**Re: Tract I-1 Mesa Del Sol, Innovation Park II
Grading and Drainage Plan
Engineer's Stamp dated 9-27-12 (R16/DA1003)**

Based upon the information provided in your submittal received 10-26-12, the above referenced report can not be approved for building permit based on the following comments:

SHEET NUMBER
C103

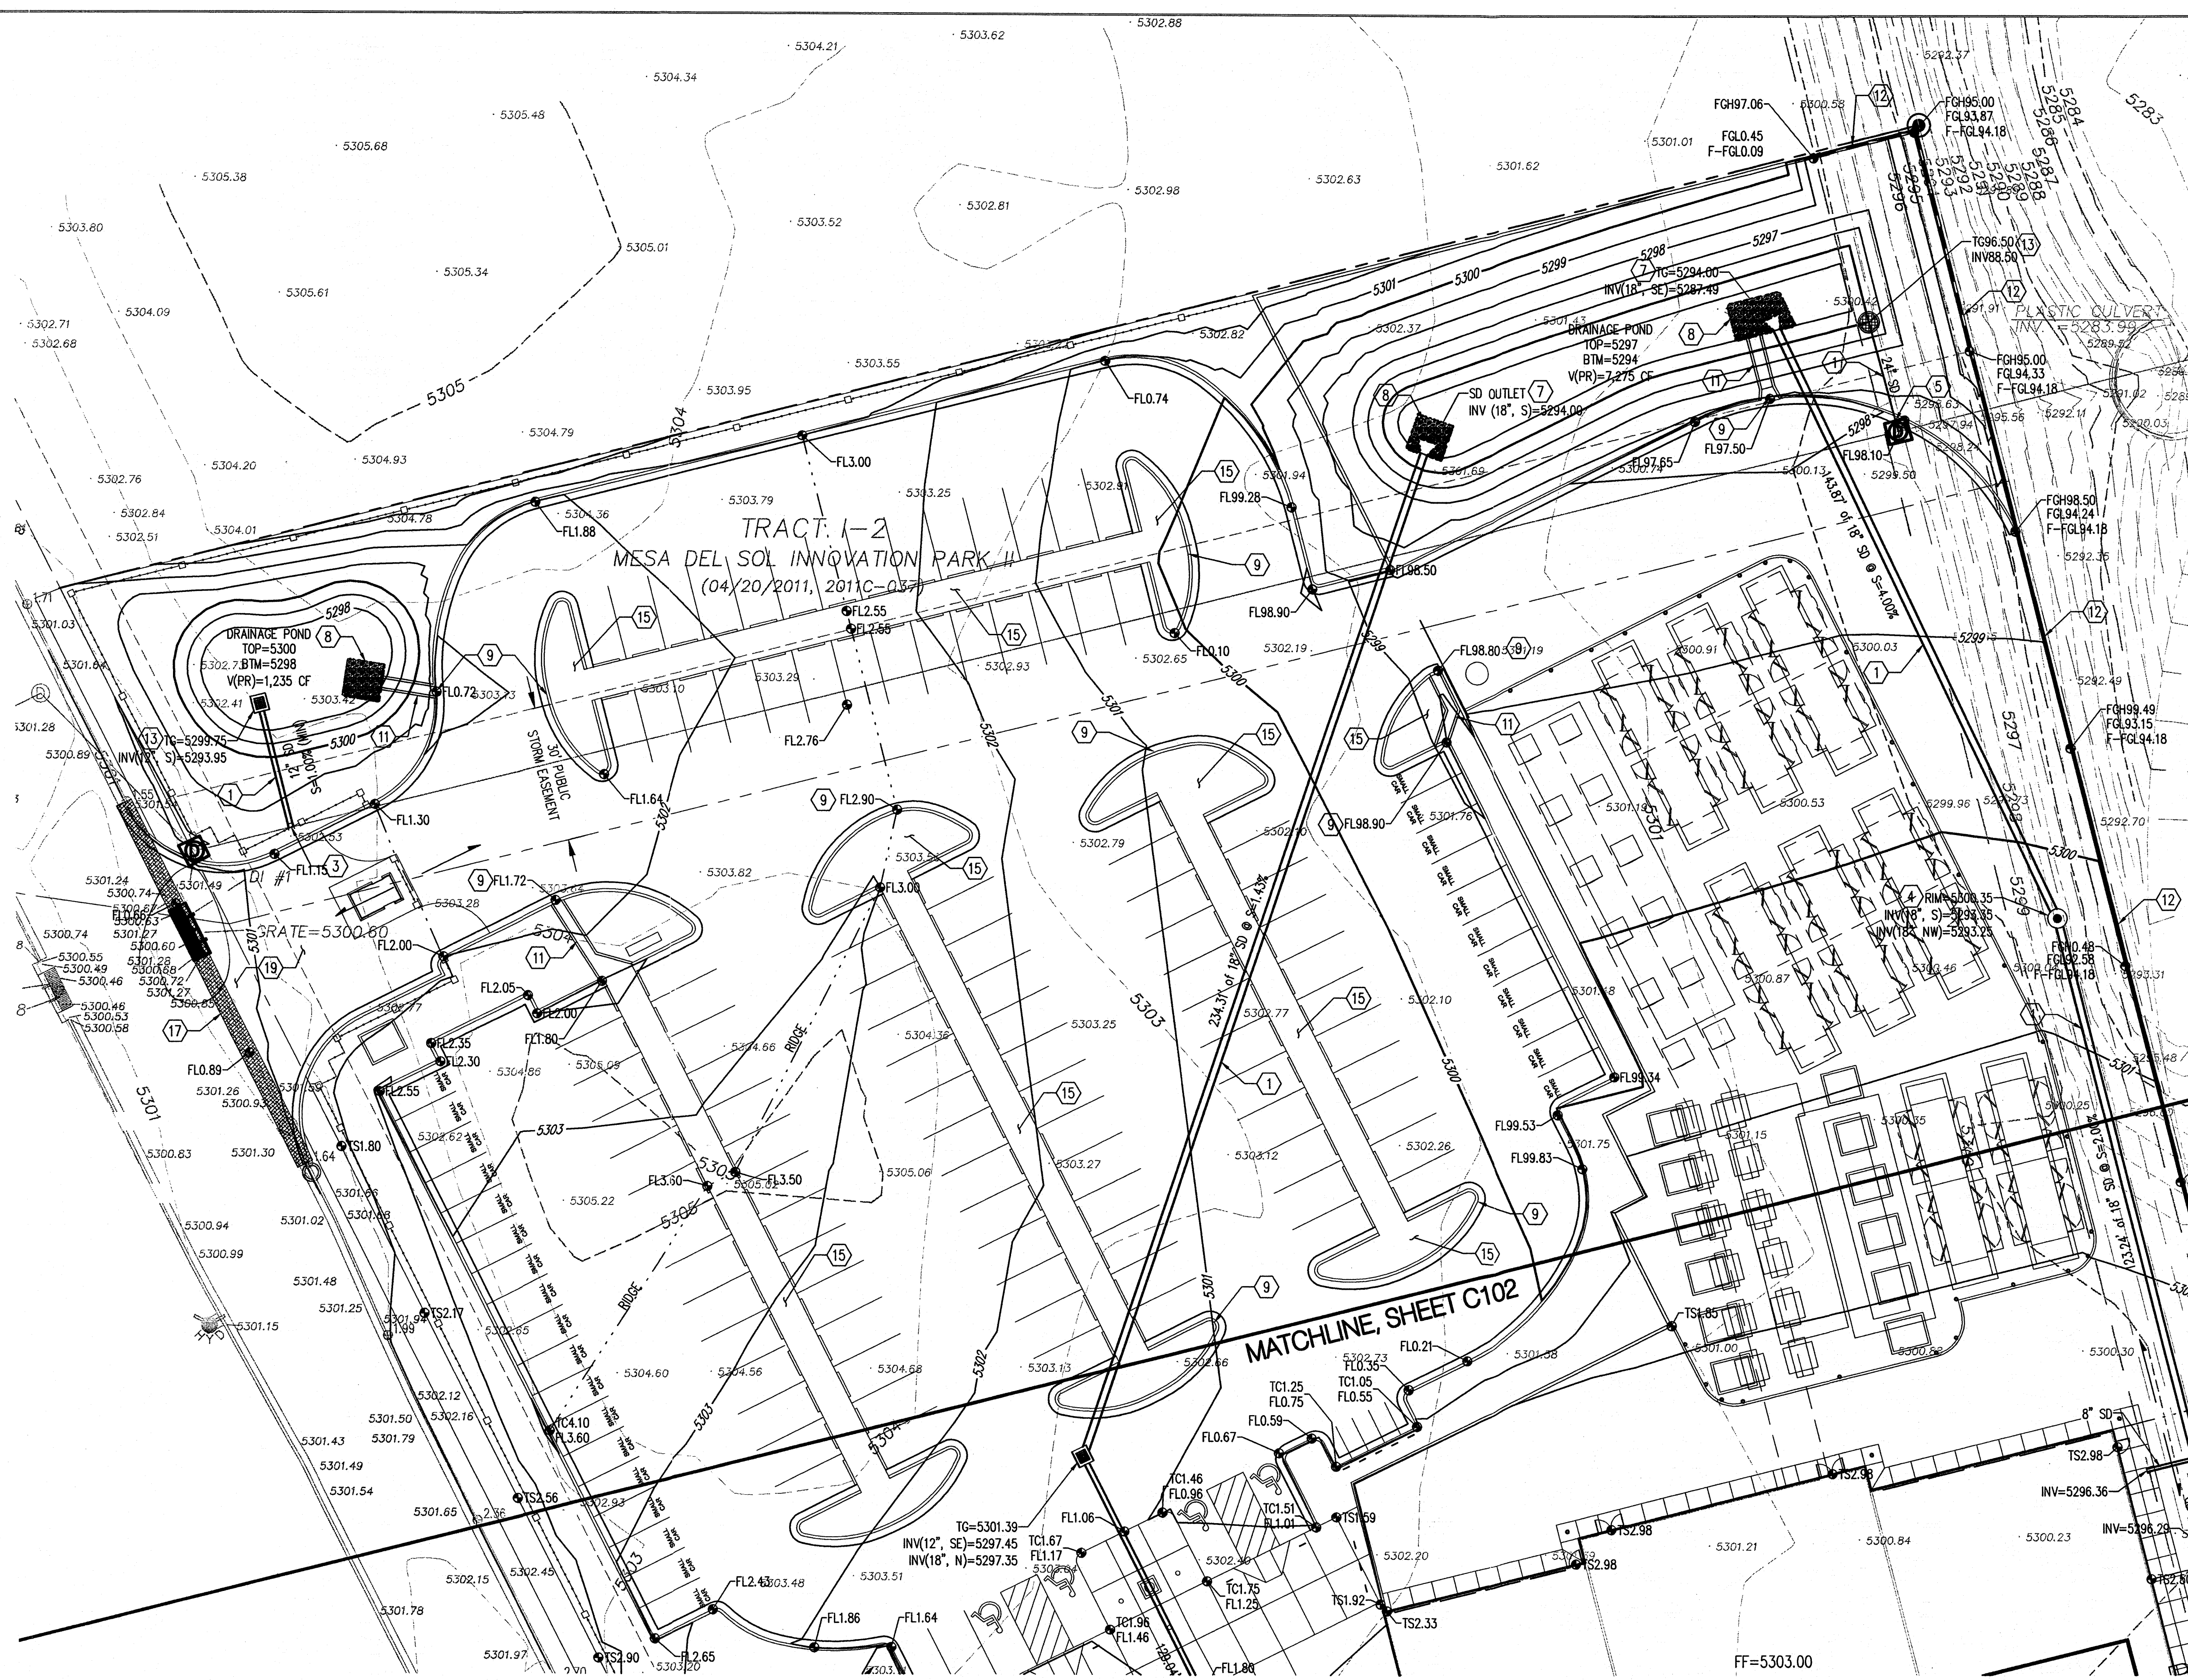
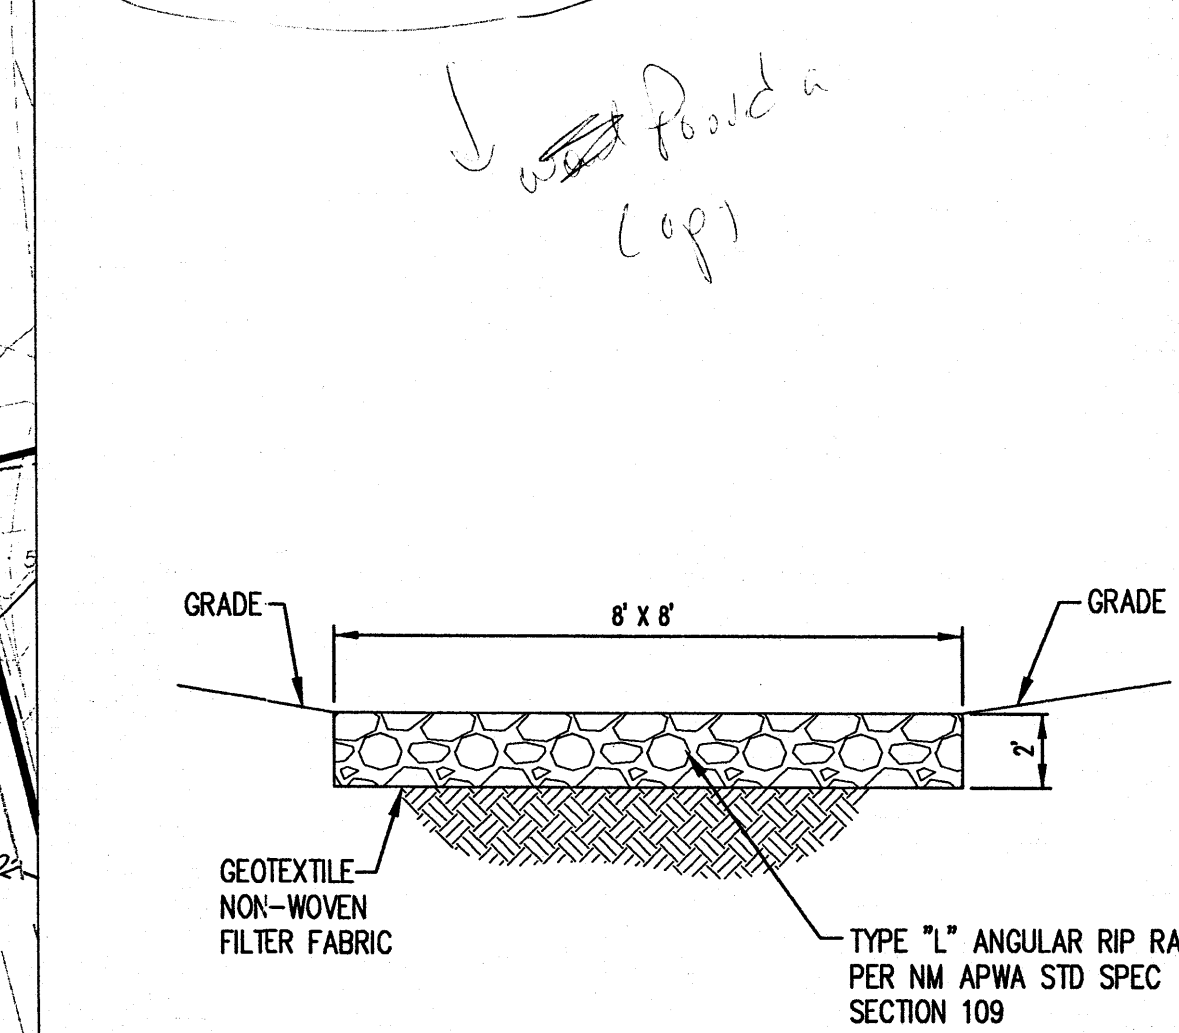
- The land treatment shown on the plan is different from the master drainage plan.
- Note 19 on sheet C103 references DRC plans. Is the note intended for the existing DRC plans for Turing Dr. SE?
